DORAN DRIVE PRECINCT SHOWGROUND

RESPONSE TO STATE DESIGN REVIEW PANEL - MEETING 4

DEICORP PROJECTS (SHOWGROUND) PTY LTD

Please find below a summary of detailed response prepared by the project team to address the items raised in the letter dated 8th April 2022 by State Design Review Panel. State Design Review Panel meeting number 4 was held on 30th March 2022.

# GROUND LEVEL PLAN - DORAN PLAZA WITH MARKET OVERLAY

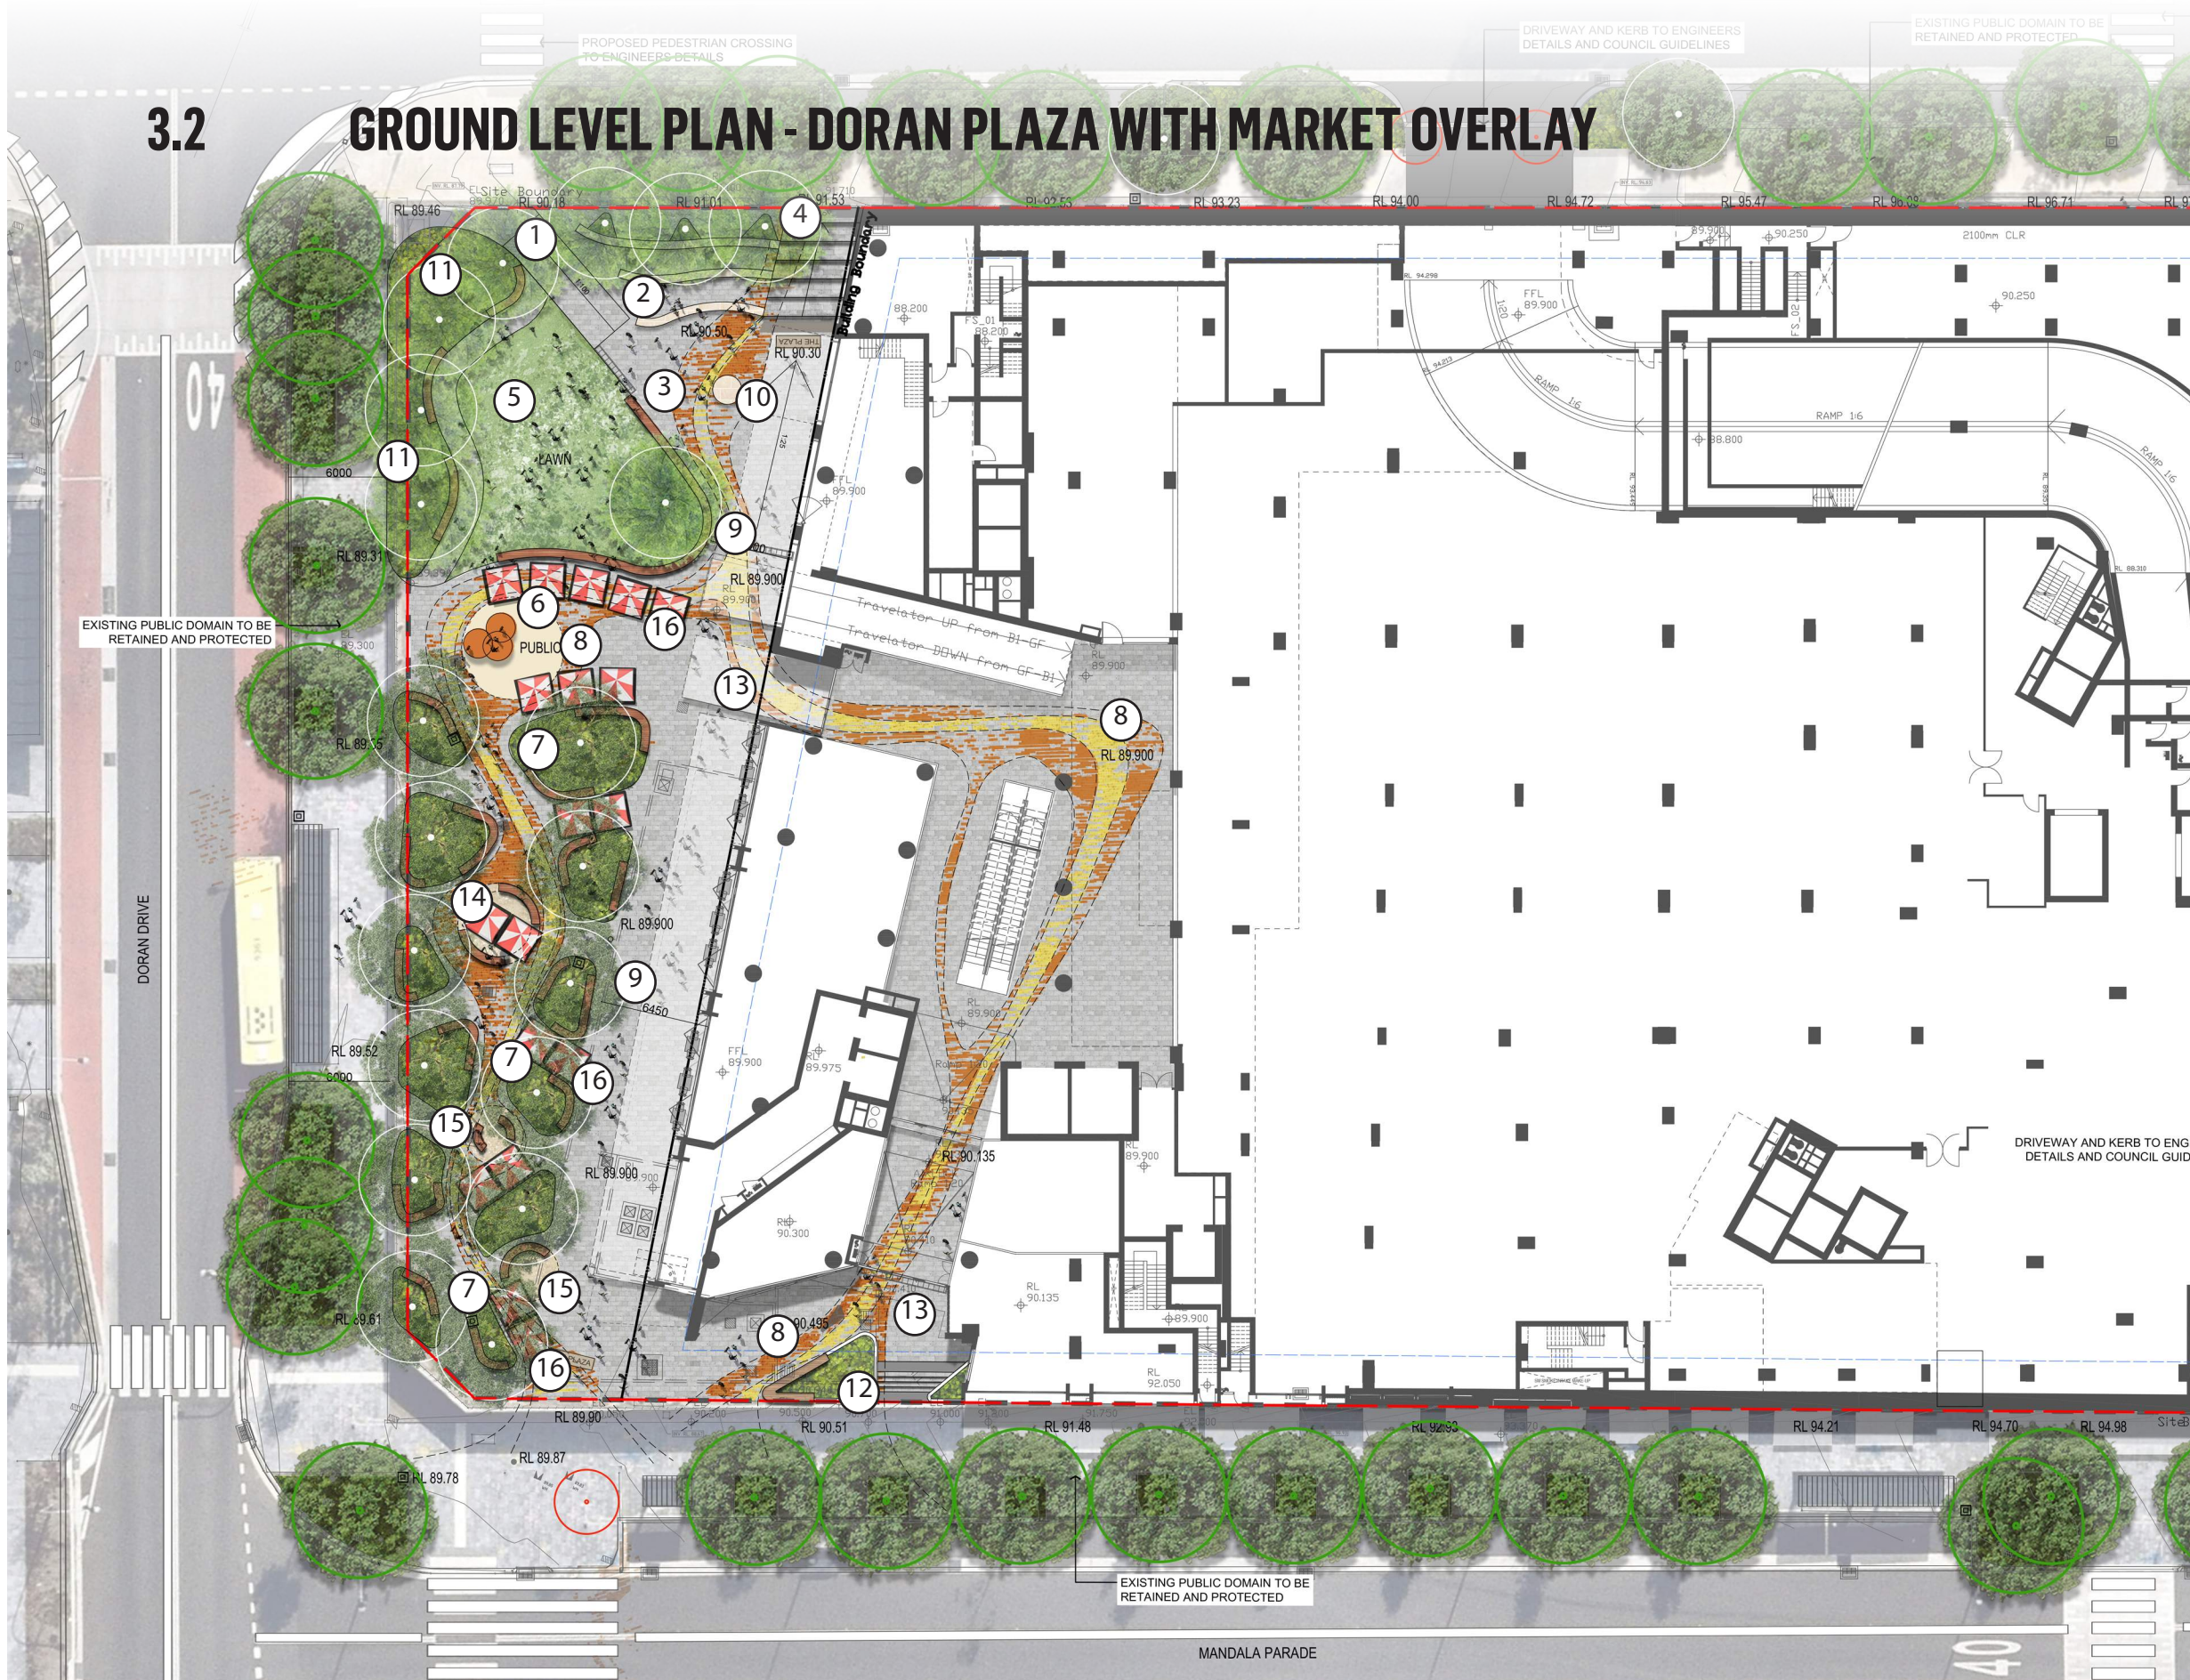
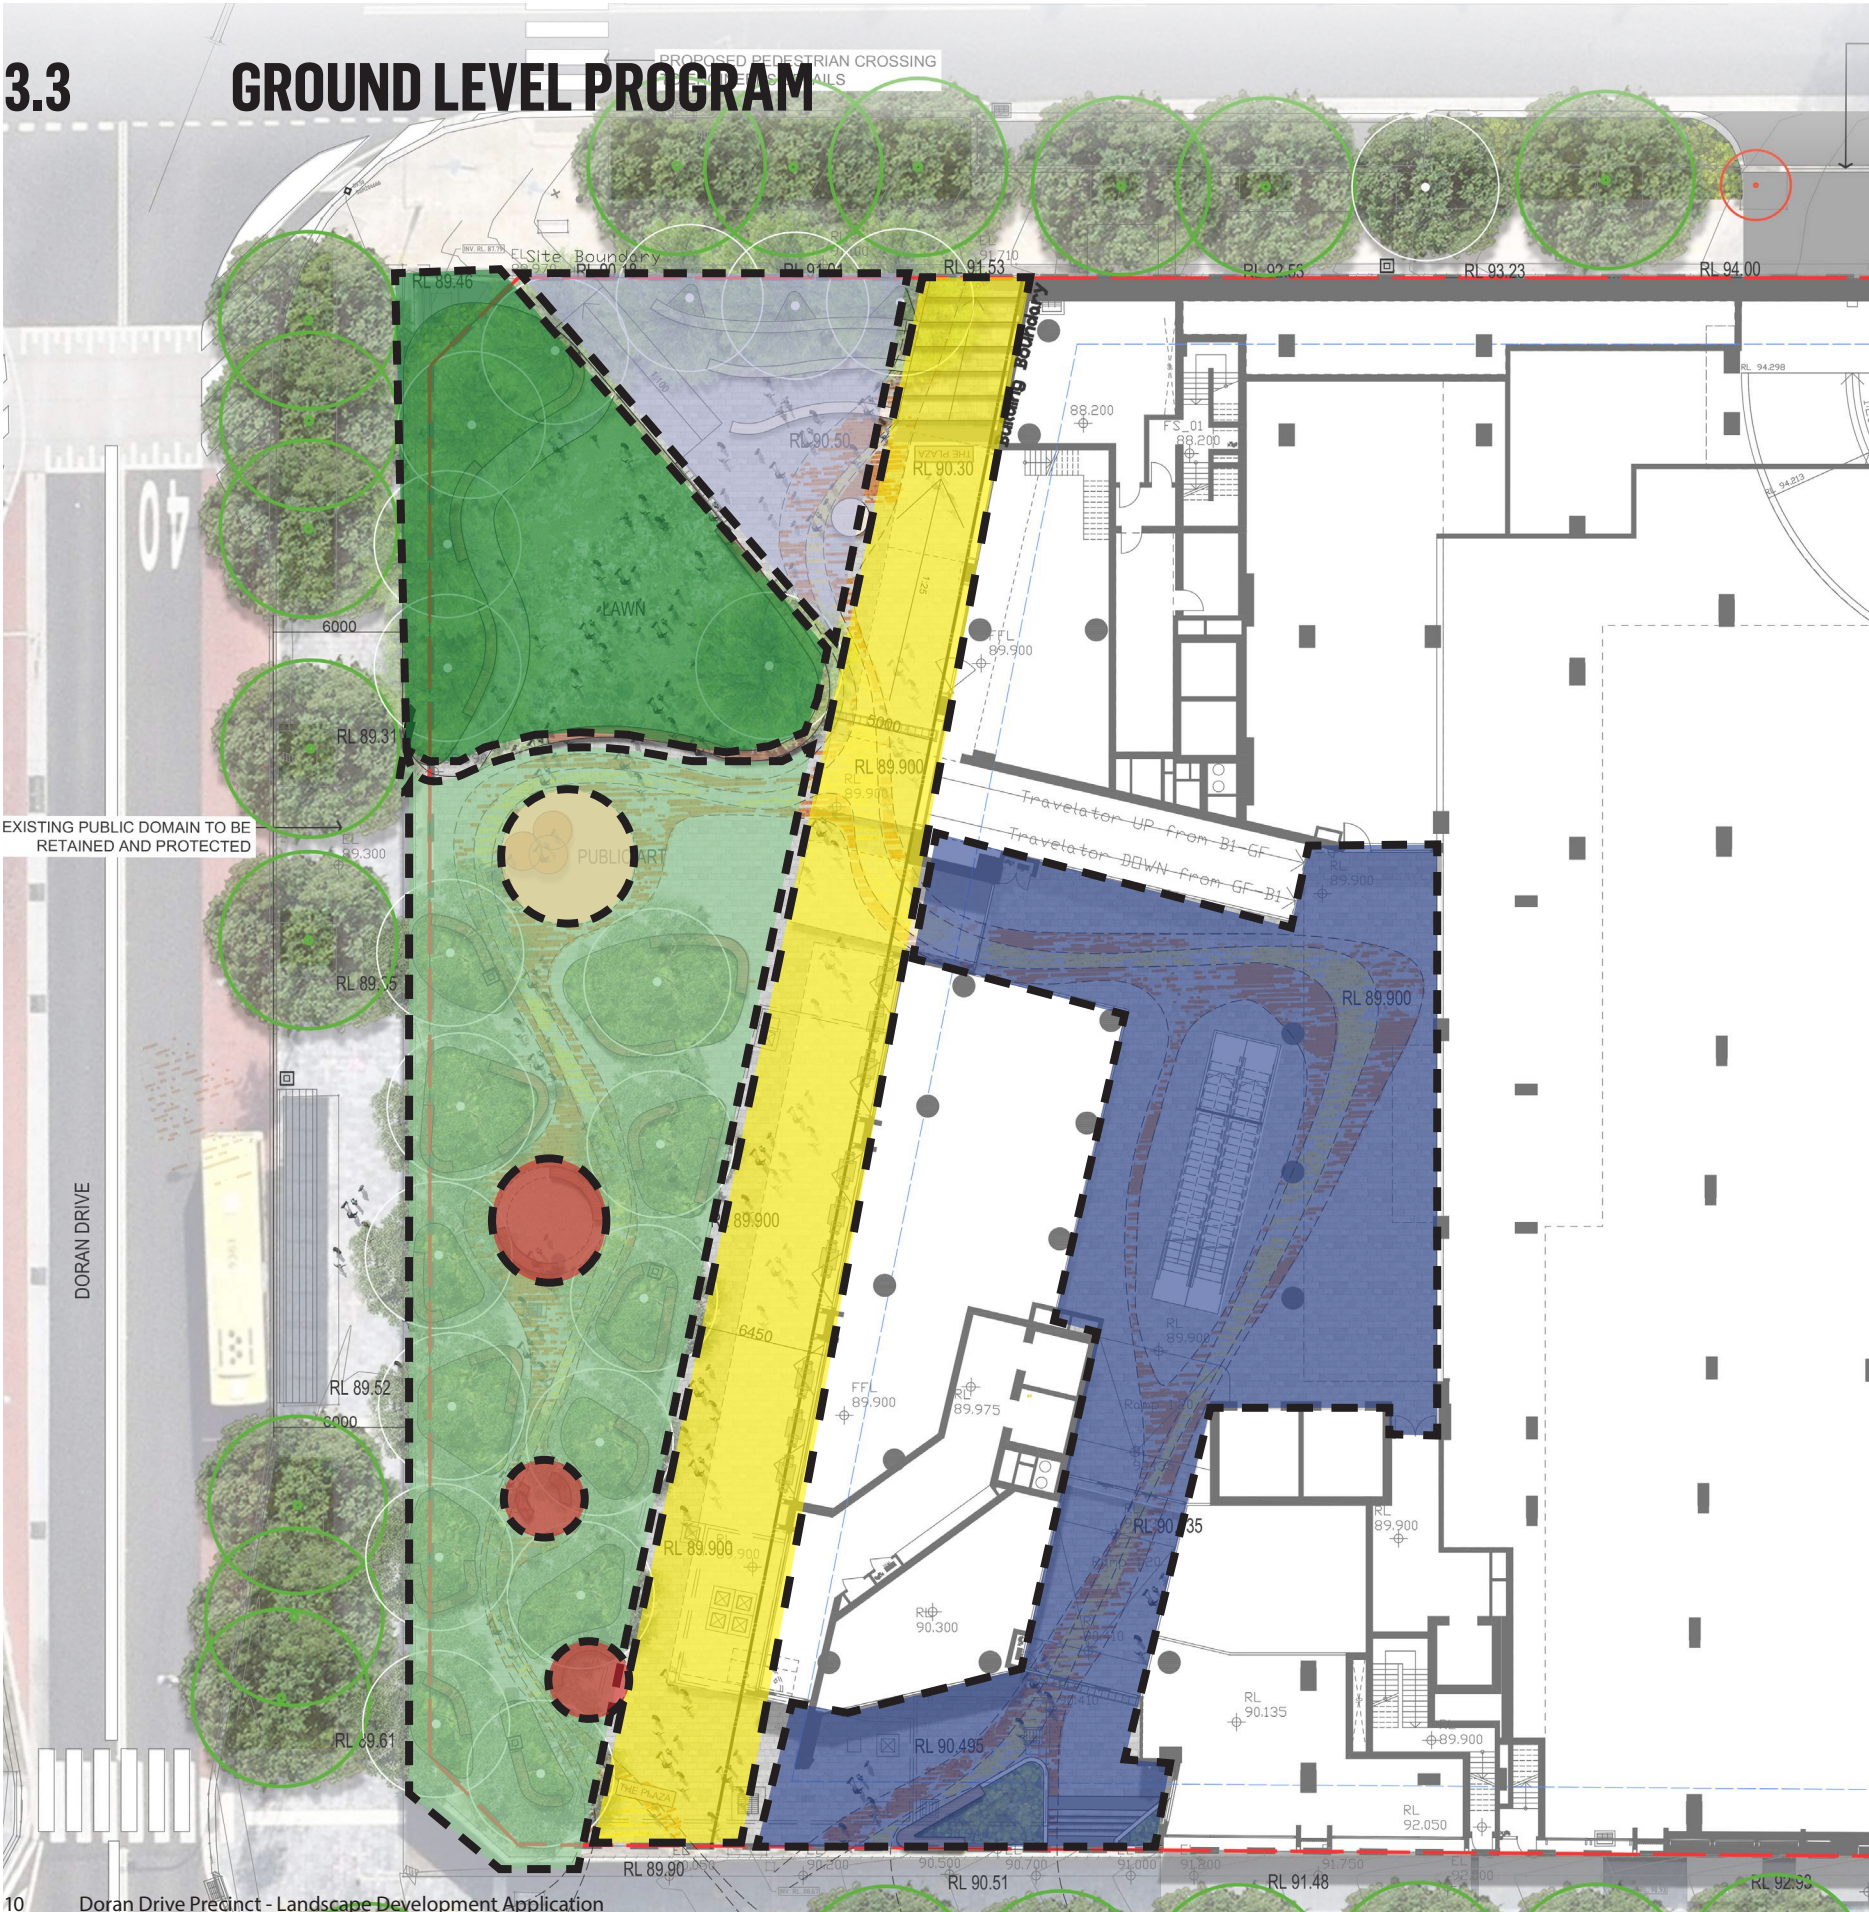
<p>PUBLIC AND OPEN SPACE</p>		
<p><u>Doran Drive Plaza</u></p> <p>There has been considerable improvement in the design of this area, particularly the understanding and expression of Country and clearer circulation generally.</p> <p>There is still some concern that outdoor dining areas will dominate the frontages and leave a very narrow corridor for sheltered circulation.</p> <p>4. Increase the projection of the awnings to improve the shading and protection to the circulation route along Doran Drive Plaza.</p>	<p>Turner James McCarthy Director / Registered Architect #10759</p>	<p>The proposal has been adjusted after SDRP 4 to allow for minimum 4m deep awnings along the full interface with Doran Drive Plaza. This depth allows for 1m of covered seating adjacent to the tenancy glass line and 3m of covered walkway for pedestrians moving from the train station towards the showgrounds. This paved external north-south circulation is over 6m in width and therefore provides a very generous and well considered zone for movement. The 4m deep awnings are further complemented by the extensive tree canopy coverage within Doran Drive Plaza that creates a high level of comfort for the users of this space.</p>

# 3.7 LEVEL 3 PLAN

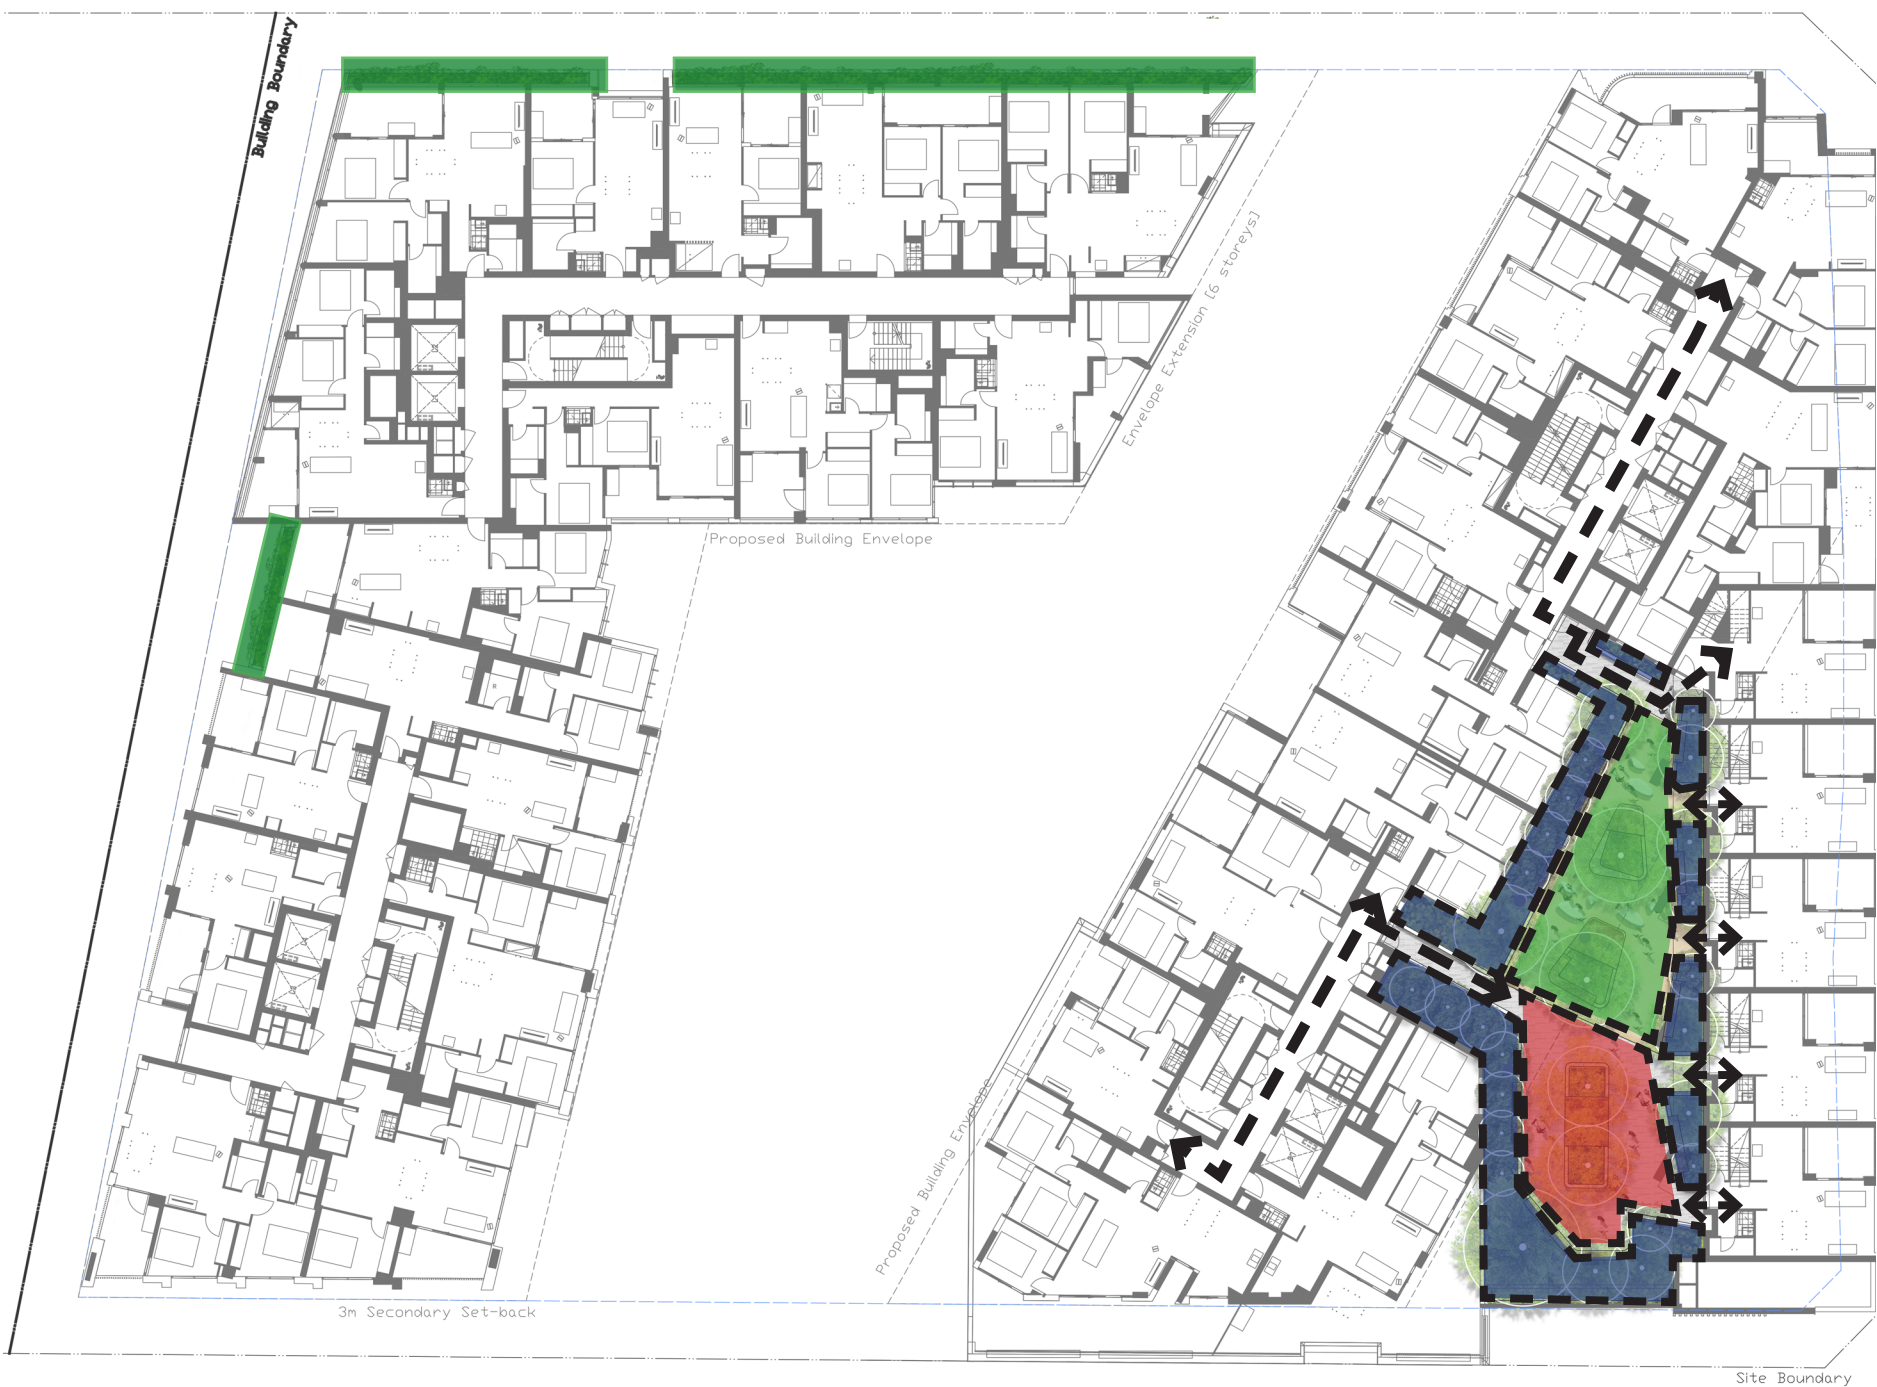
<p>The undercroft condition on level 3 between Tower D and the townhouses, results in a very narrow planting area that will be overshadowed for much of the time and unlikely to support jacaranda tree canopy as proposed. This space seems unsuited as communal open space.</p>	<p>Urbis Mark Kuhne Director / Registered Landscape Architect #1226 (AILA)</p>	<p>We have reviewed the suitability of the Jacaranda in this space and agree a shade tolerant tree species such as Elaeocarpus species a native rainforest tree would be more appropriate.</p>
<p>7. A review of programming and planting for the podium spaces is recommended.</p>	<p>Urbis Mark Kuhne Director / Registered Landscape Architect #1226 (AILA)</p>	<p>See Items 3. and 3b. above.</p>
<p>ARCHITECTURE</p>		
<p>The project clearly presents significant design challenges - delivering high density on the site while accommodating a large, predetermined public space, thru site links and connectivity with the Metro station.</p>
